**COLORADO**  
**Department of Transportation**

June 4, 2020

RE: Trails at Aspen Ridge Filing #2 (Springs East at Waterview) - EA-SF1927

Trails at Aspen Ridge PUD (LSC #184362)

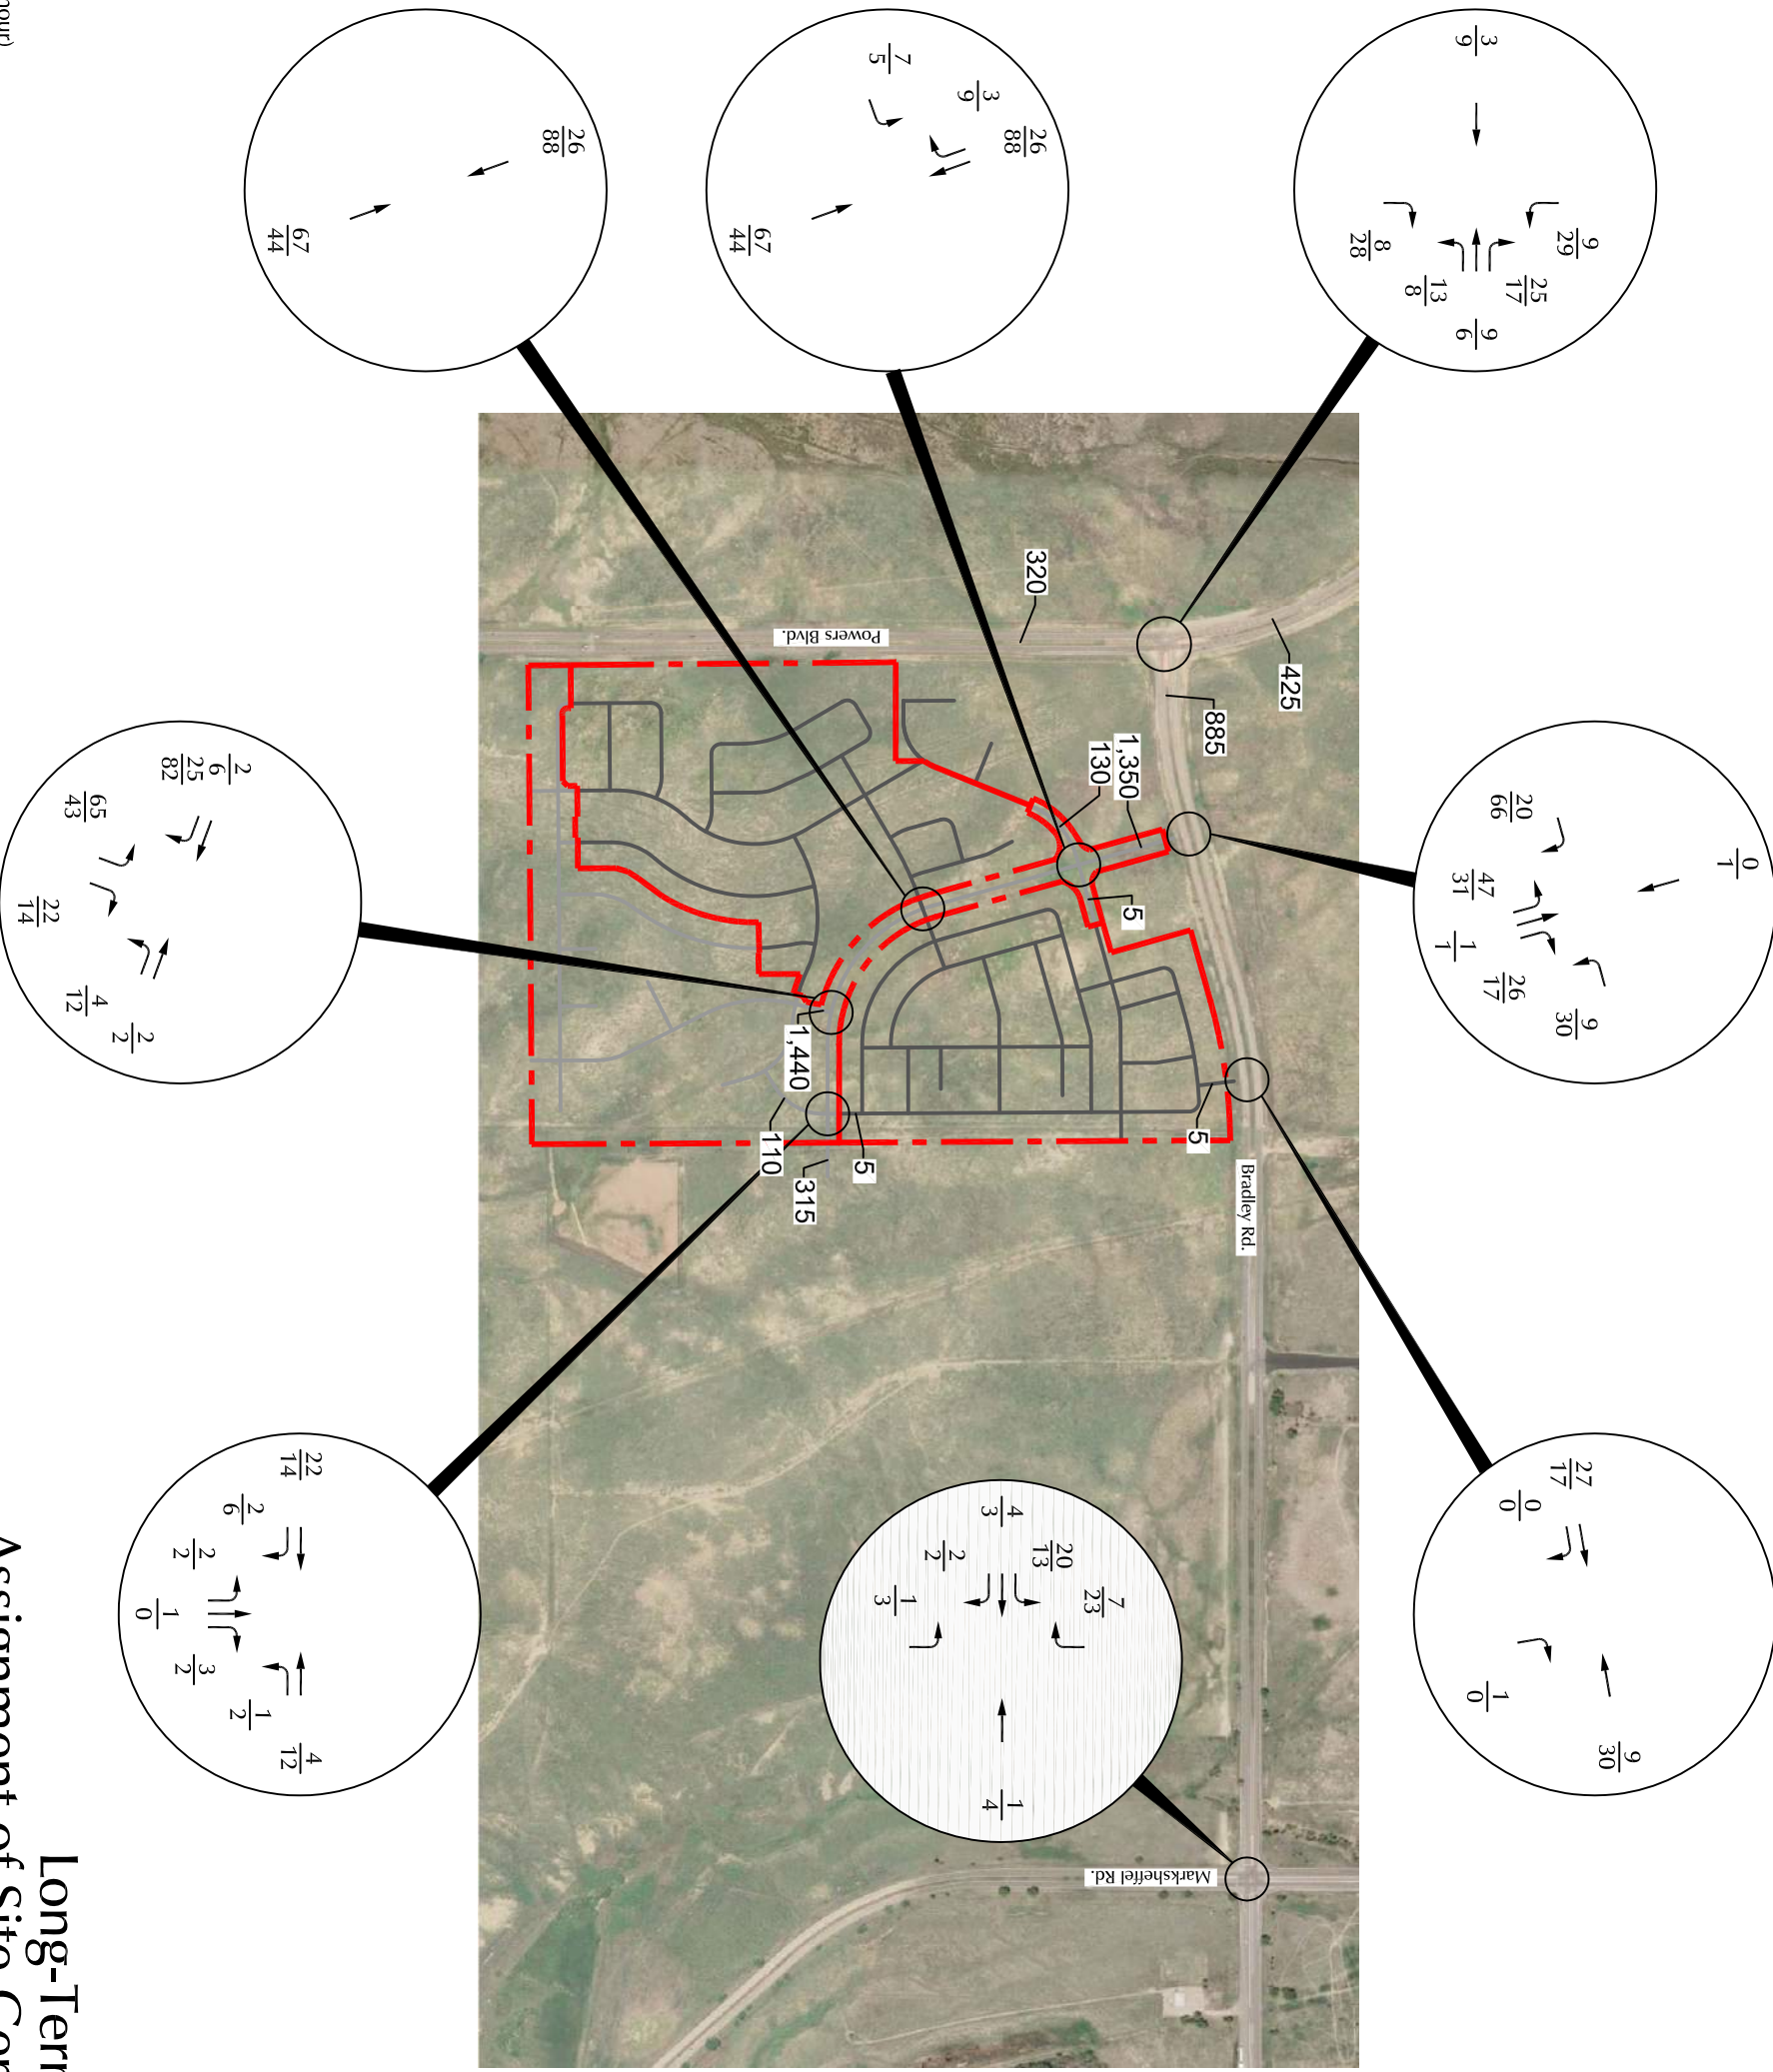
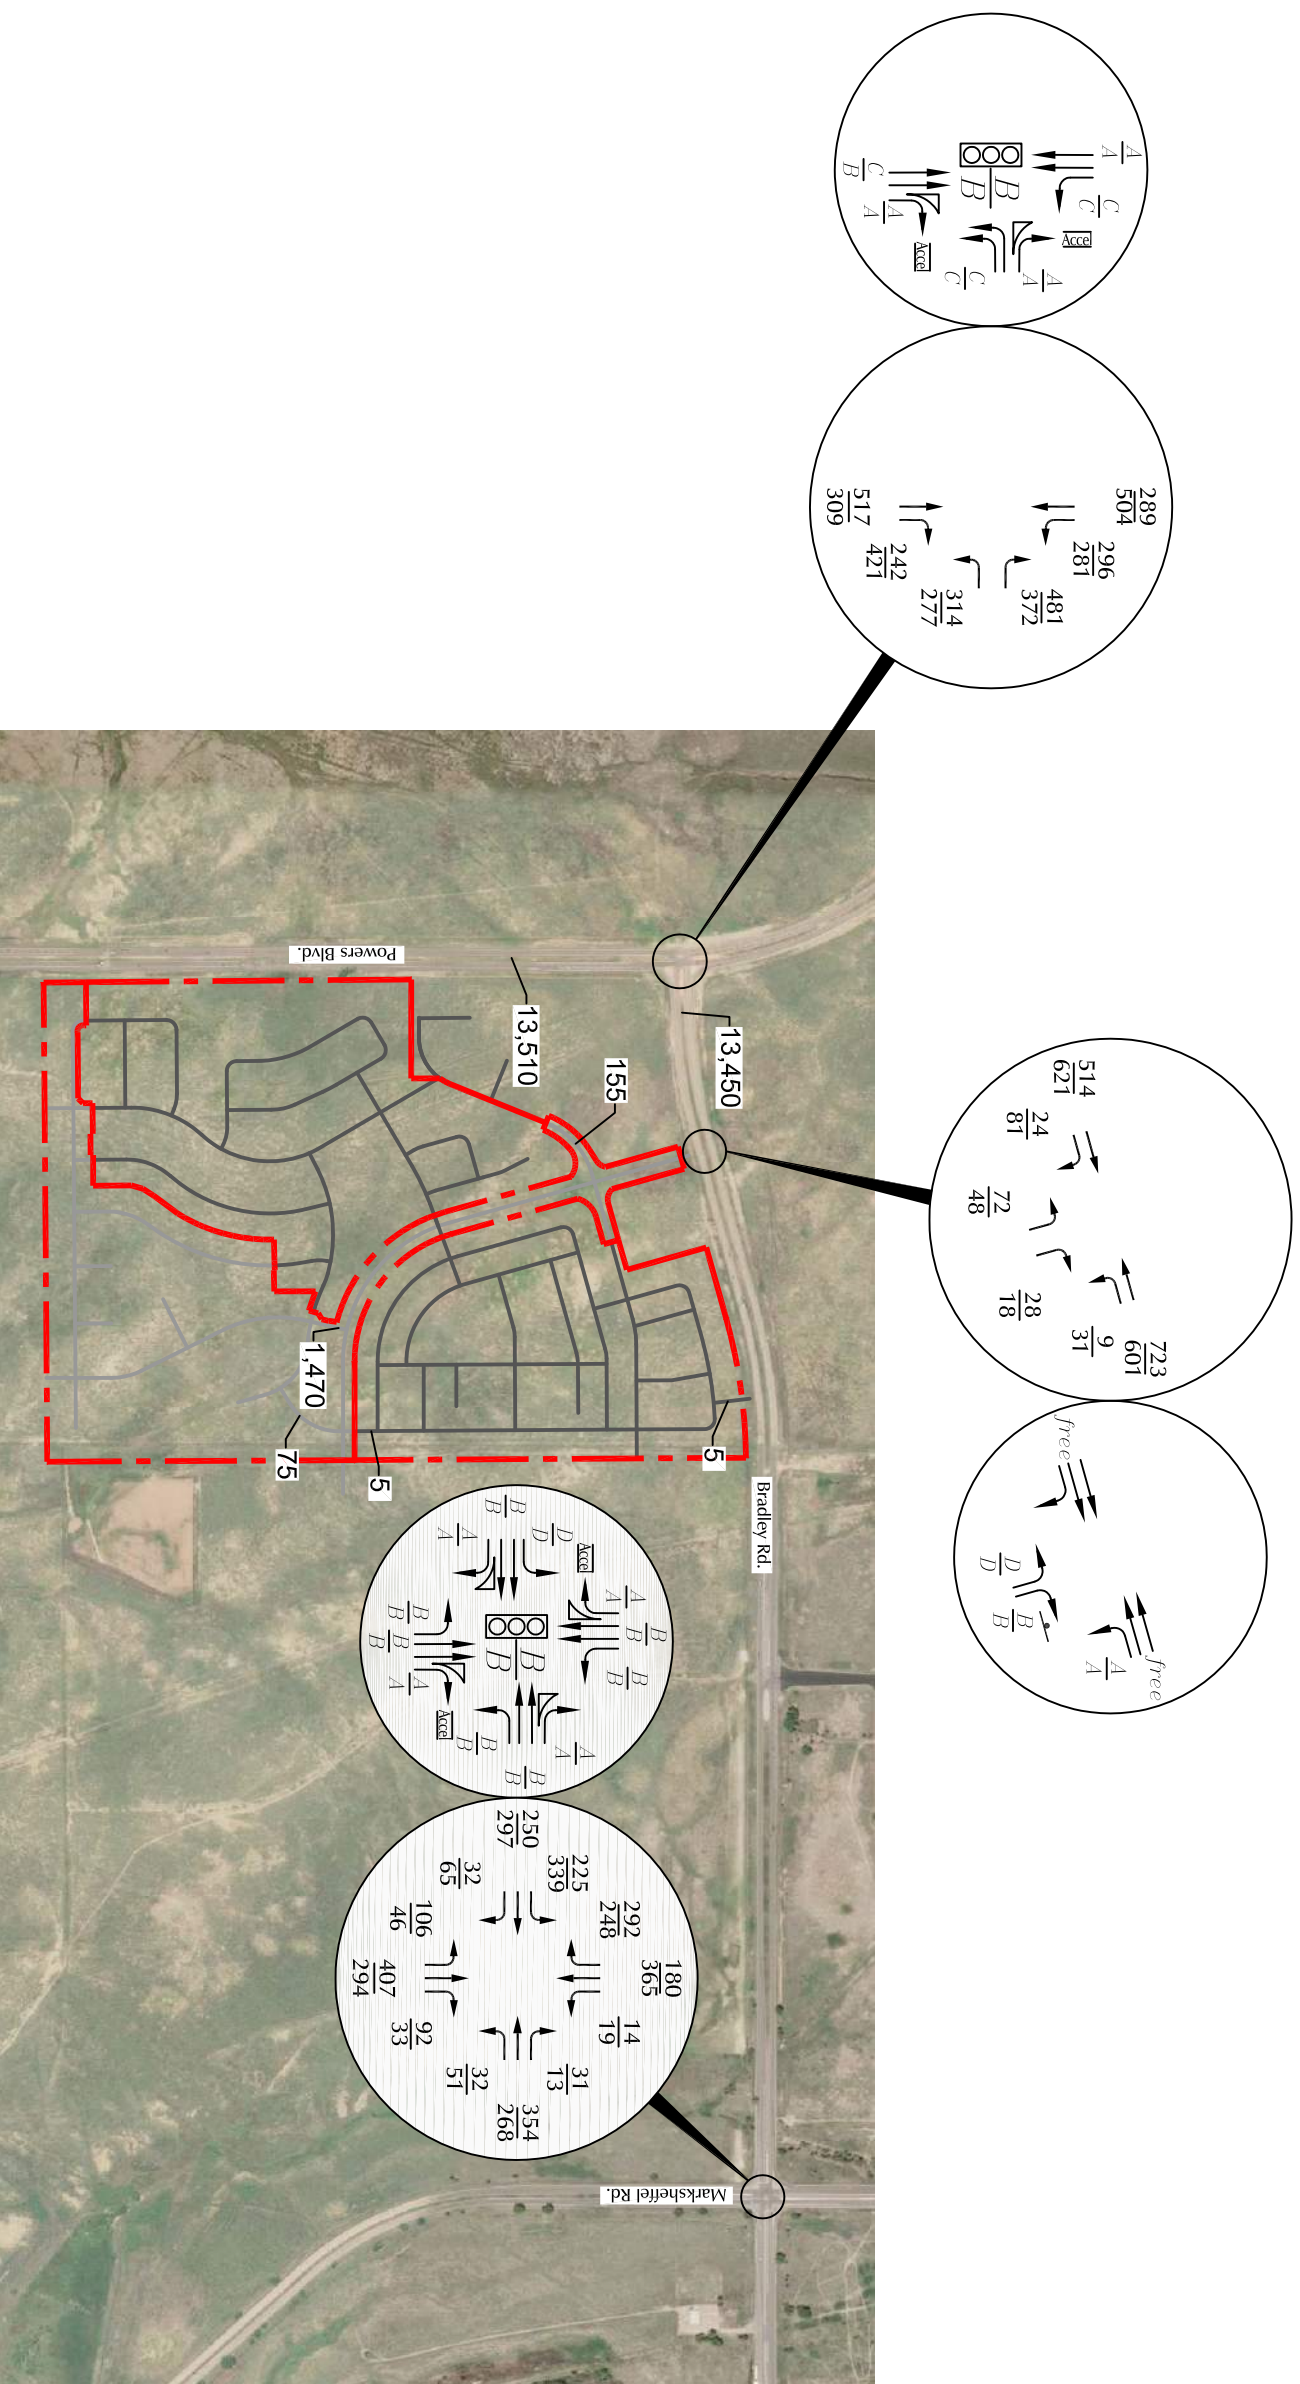
- g. The 2040 Synchro reports for Powers Blvd. Interchange Northbound Ramp at Bradley Rd is missing the existing left turn traffic in both time periods from Figure 13. Please update Figure 13.
